From: Laura Gibbons
Sent: 01 August 2018 09:04
To: Planning.Responses
Subject: RE: Planning Consultation on: FP/171/18/PL

Engineers Comments Relating to Surface Water Drainage

APPLICATION FP/171/18/PL

Description of Works: Erection of 18 No. dwellings, creation of new access, landscaping & associated works.

Client	MJA CONSULTING CIVIL AND STRUCTURAL ENGINEERS Monarch House, Barton Lane, Abingdon, Oxon, OX14 3NB Tel: 01235 555173 Fax: 01235 523226		
Project	Felpham		
Title	Engineering Layout	Scale 1:200@A1 Checked KTG	Date Mar'18 Drawn JRV
Drawing No.	5782:01	Rev C

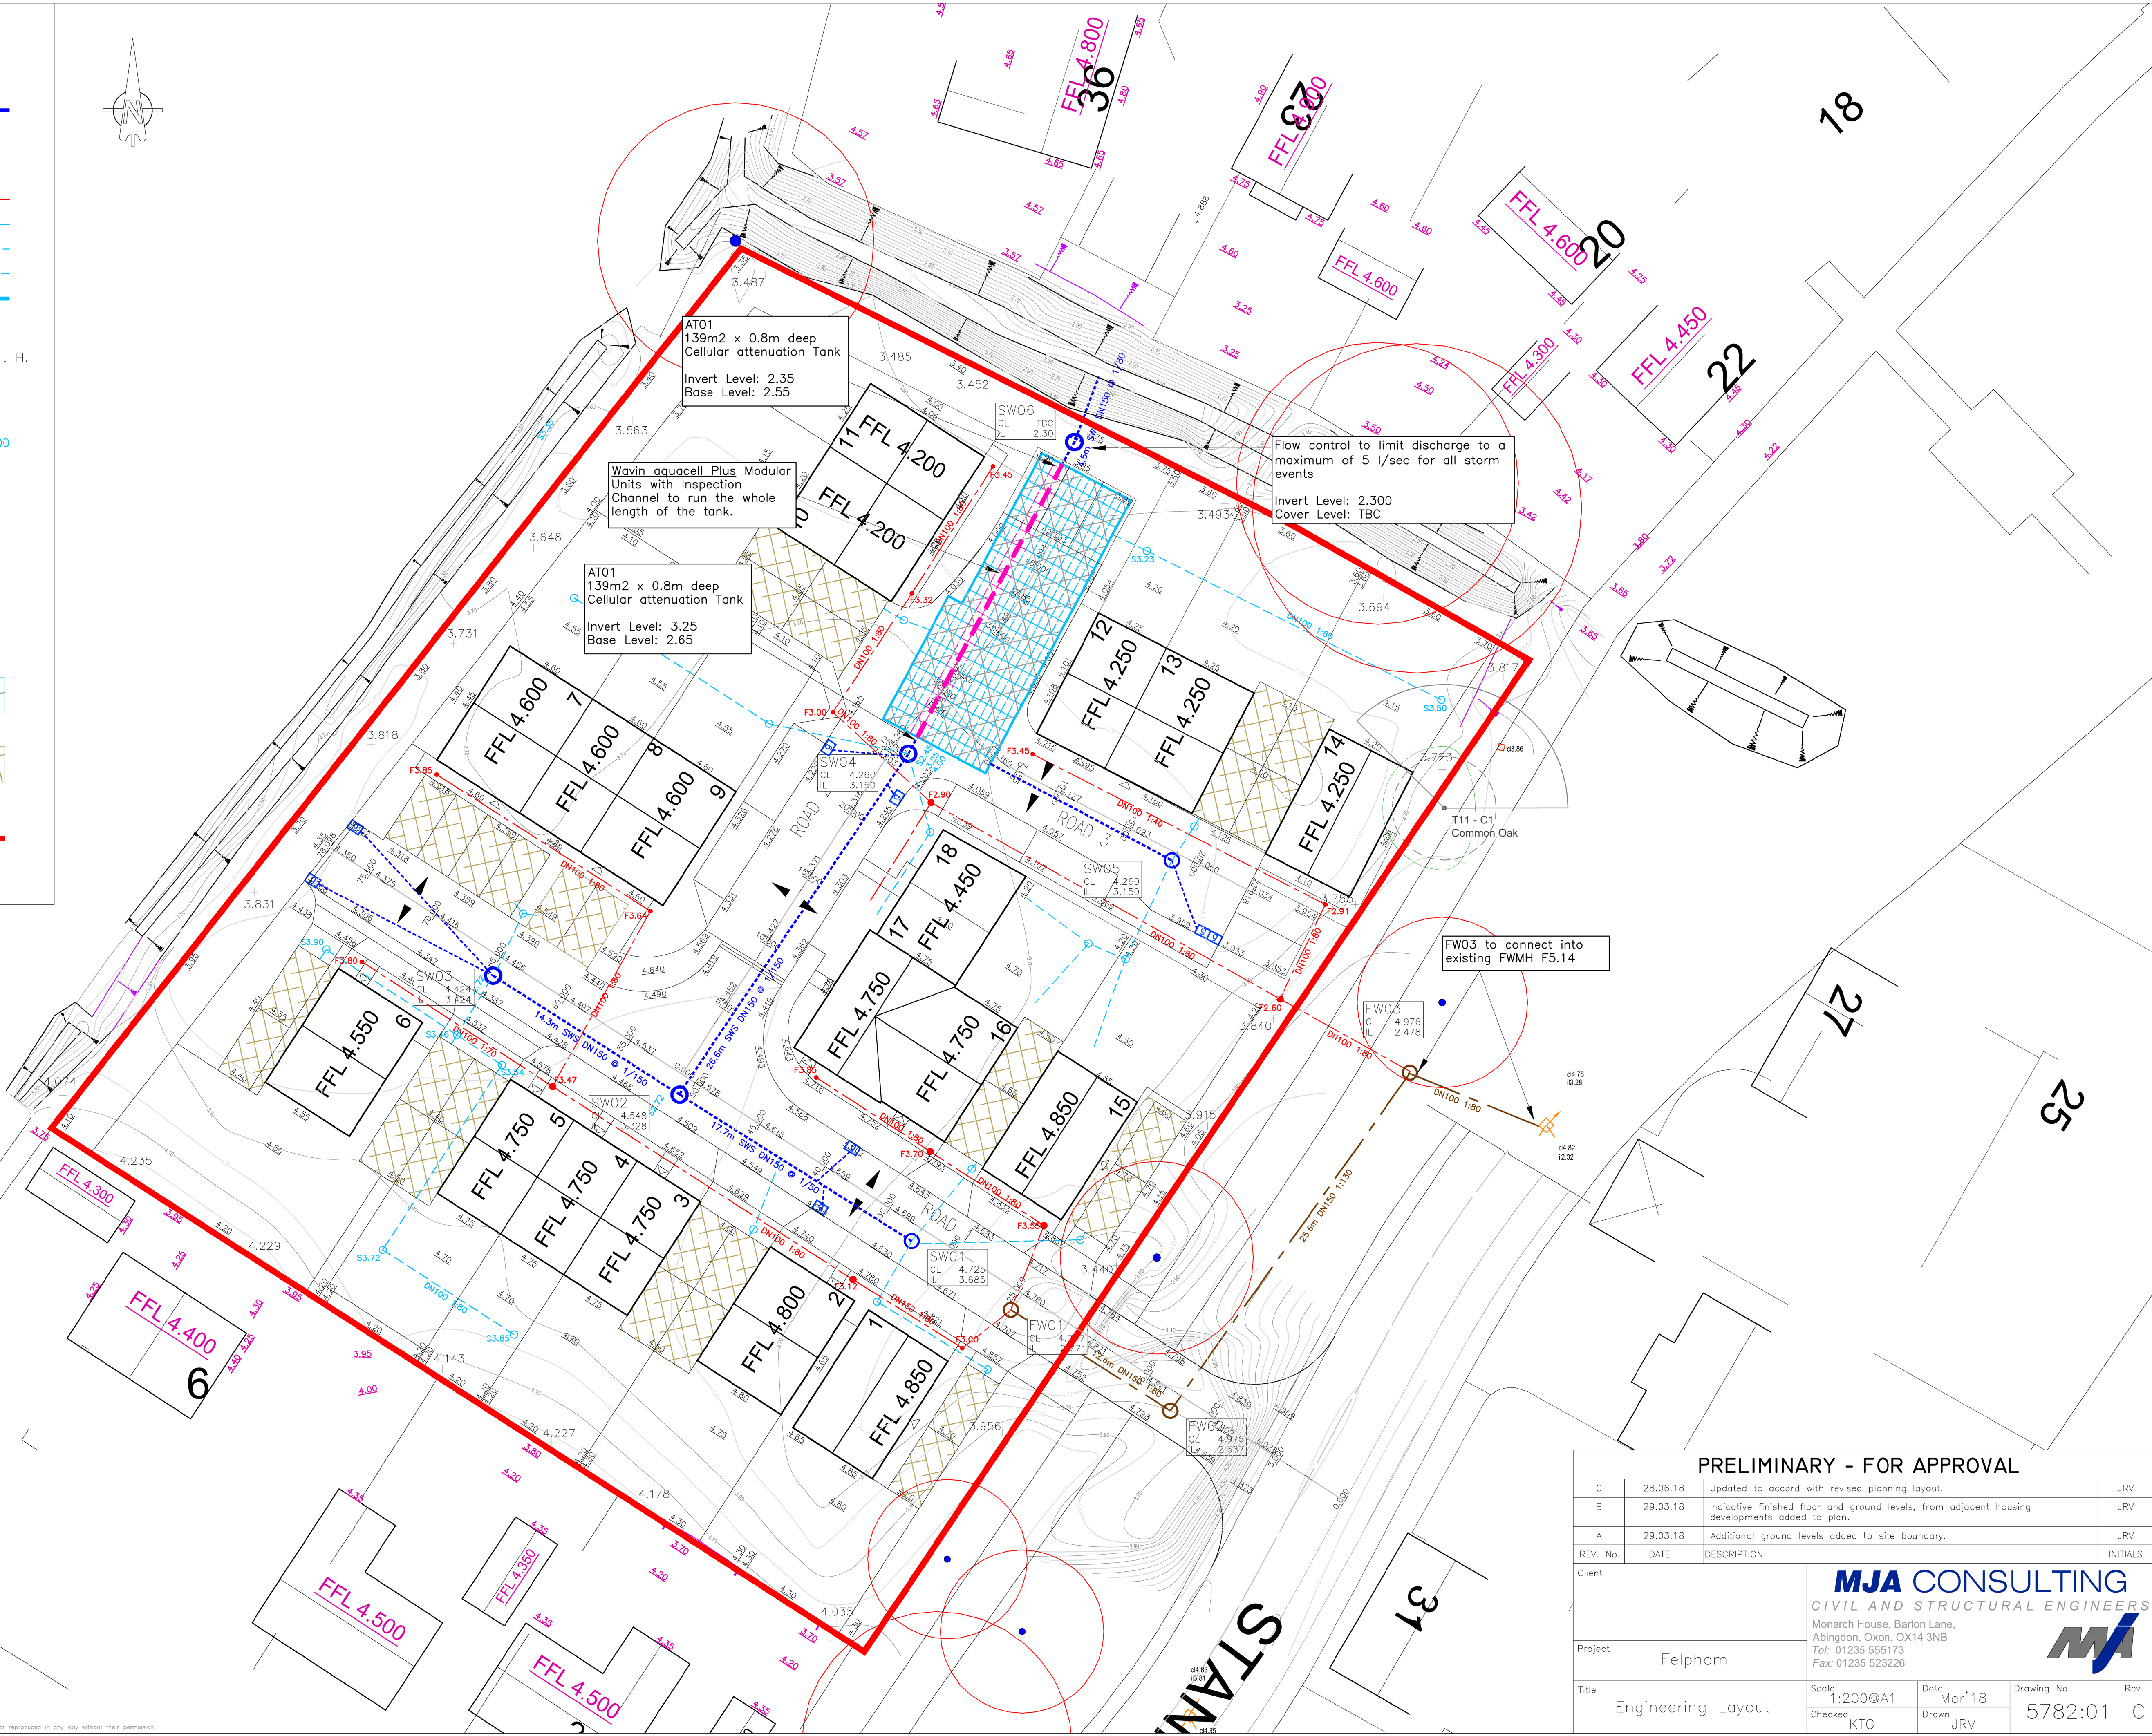
Infiltration must be investigated for surface water disposal. No evidence has been submitted to support the statement that the site is not suitable for infiltration. A drainage strategy is referenced within the drainage statement but has not been supplied. Winter groundwater monitoring and percolation test results will need to be submitted.

It should also be noted that the current proposed discharge rate of 5l/s is too high, QBar greenfield runoff rate for the site is 1.45l/s, please provide justification why such a high rate is proposed.
